# DART+WEST ORAL HEARING

Cllr John Walsh

# Ashtown

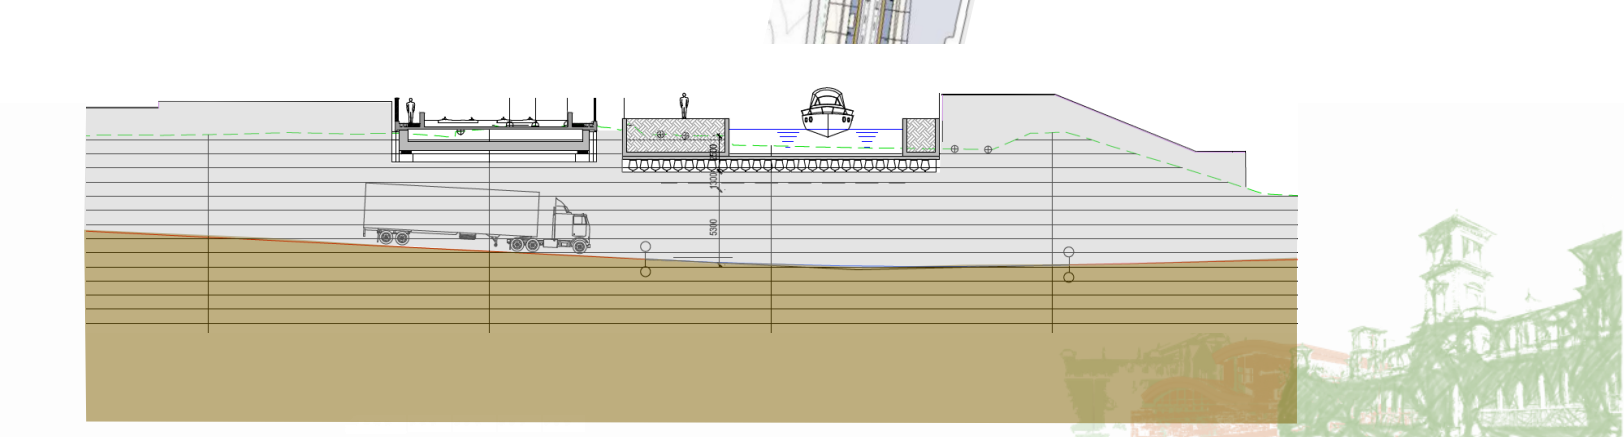
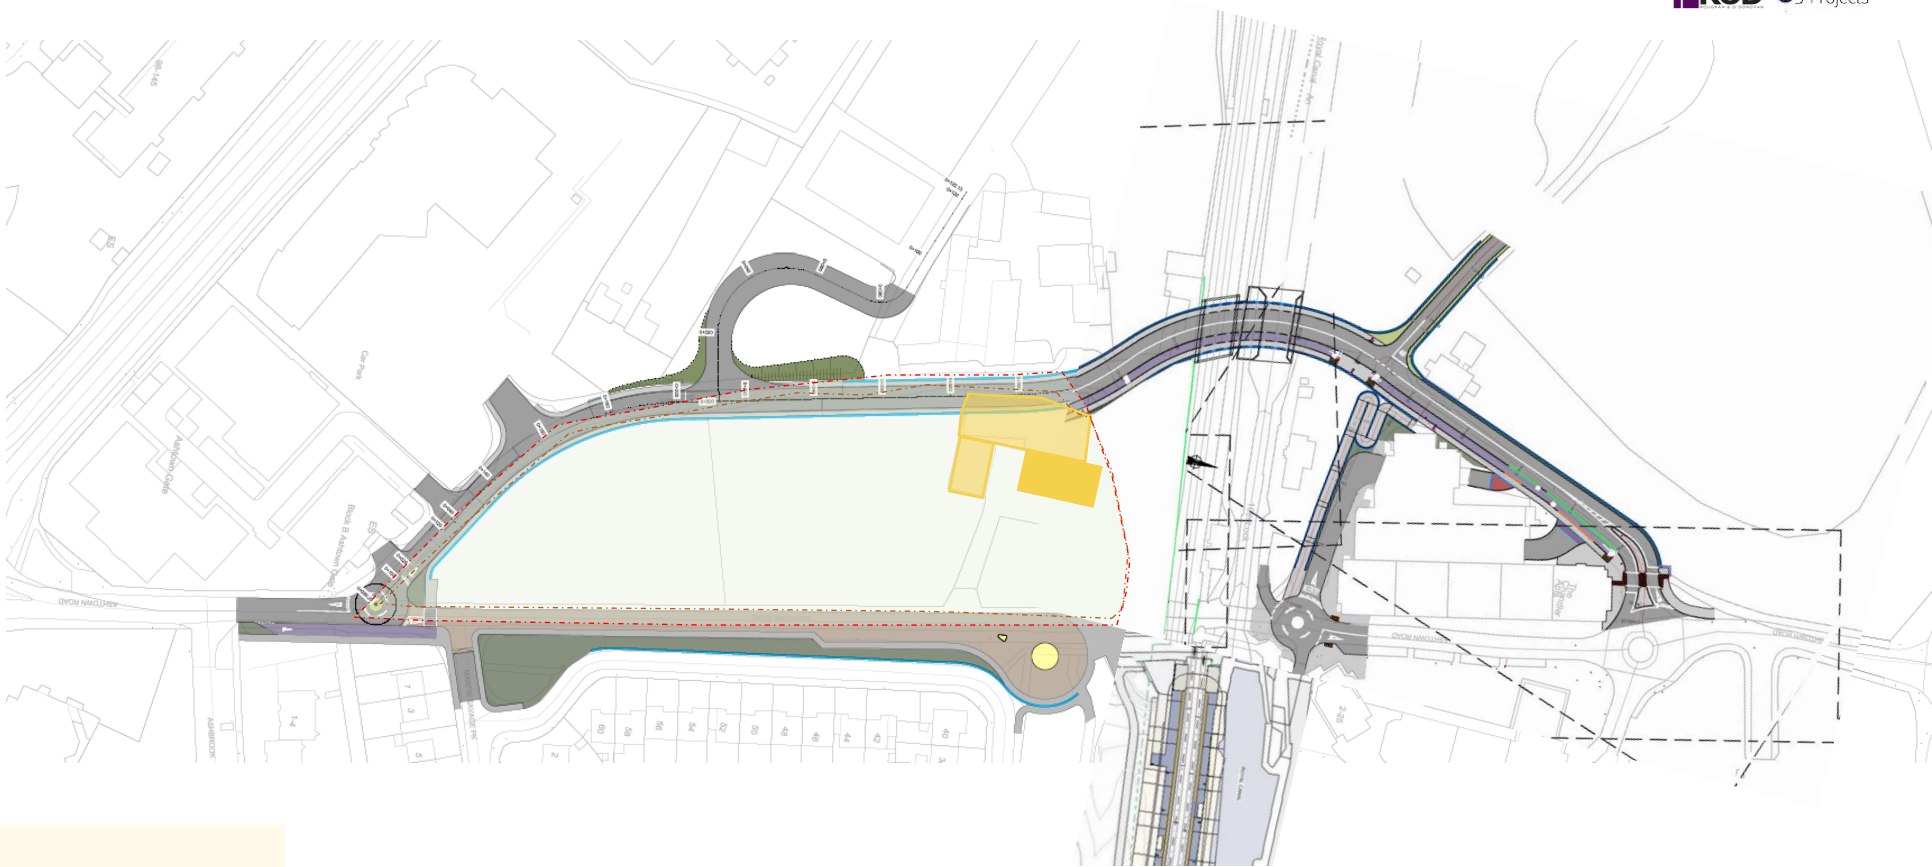
- Current proposal for a tunnel will have a significant and disproportionate impact on Ashtown stables.
- Ashtown stables are operating on the bare minimum footprint for their activity and Irish Rail's current plans would turn an unnecessarily large area around the Stables into a construction site. This would render Ashtown Stables non-viable and force the stables to close.
- It should not be acceptable to allow the loss of such a valuable community and recreational amenity which serves young people across the Dublin 15 and Navan Road area.
- Clarify impact on neighbouring estates such as Martin Savage Park where the removal of trees should be avoided.
